Subject: DEVIATION REVIEW AND DECISION FORM

Subdivision or Project Name: Winsome

Section of ECM from Which Deviation is Sought: Section 2.25.B.1 Spacing for Rural Minor Arterial

Proposed Nature and Extent of Deviation: The standard is 0.25 mile (1,320') intersection spacing. The proposed
intersection is spaced at approximately 780' (measured to center intersection).

HODGEN RD  
IMPROVEMENTS

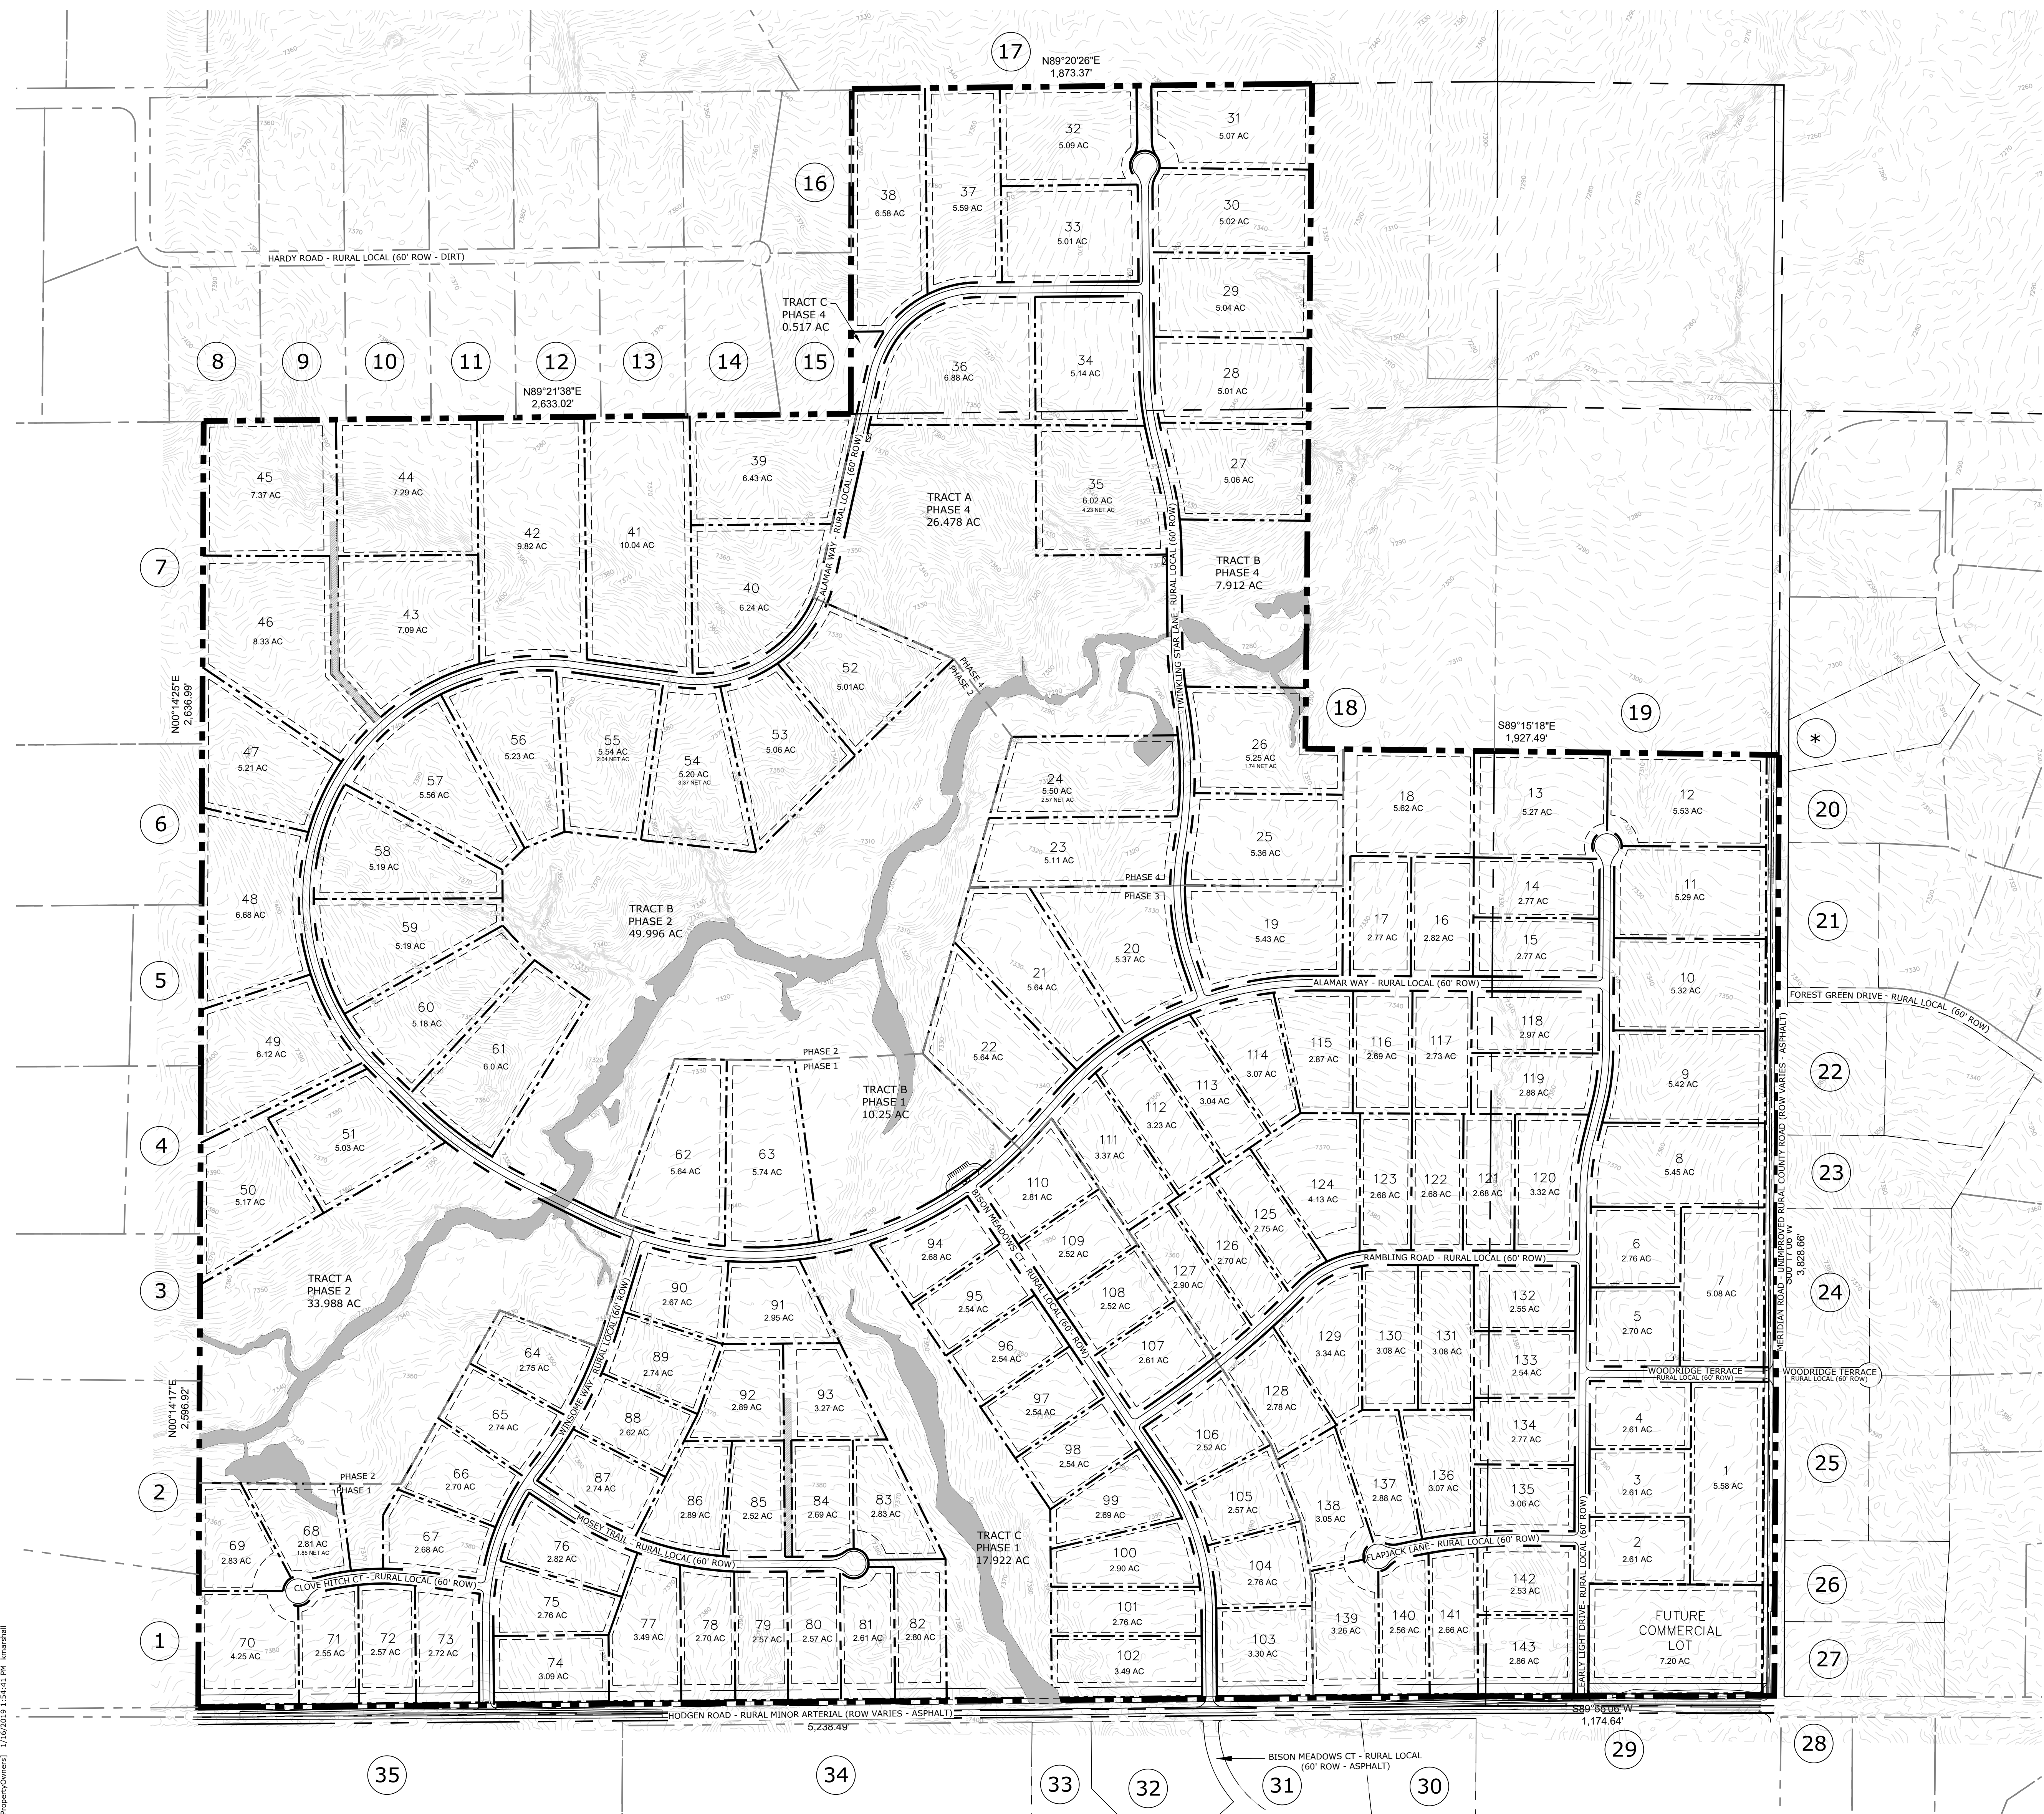
Elaborate on the justification/reason. There are two other access points on Hodgen plus one on Meridian Road. Why can't the internal roadway be reconfigured to remove the third access (Early Light Drive) on Hodgen?
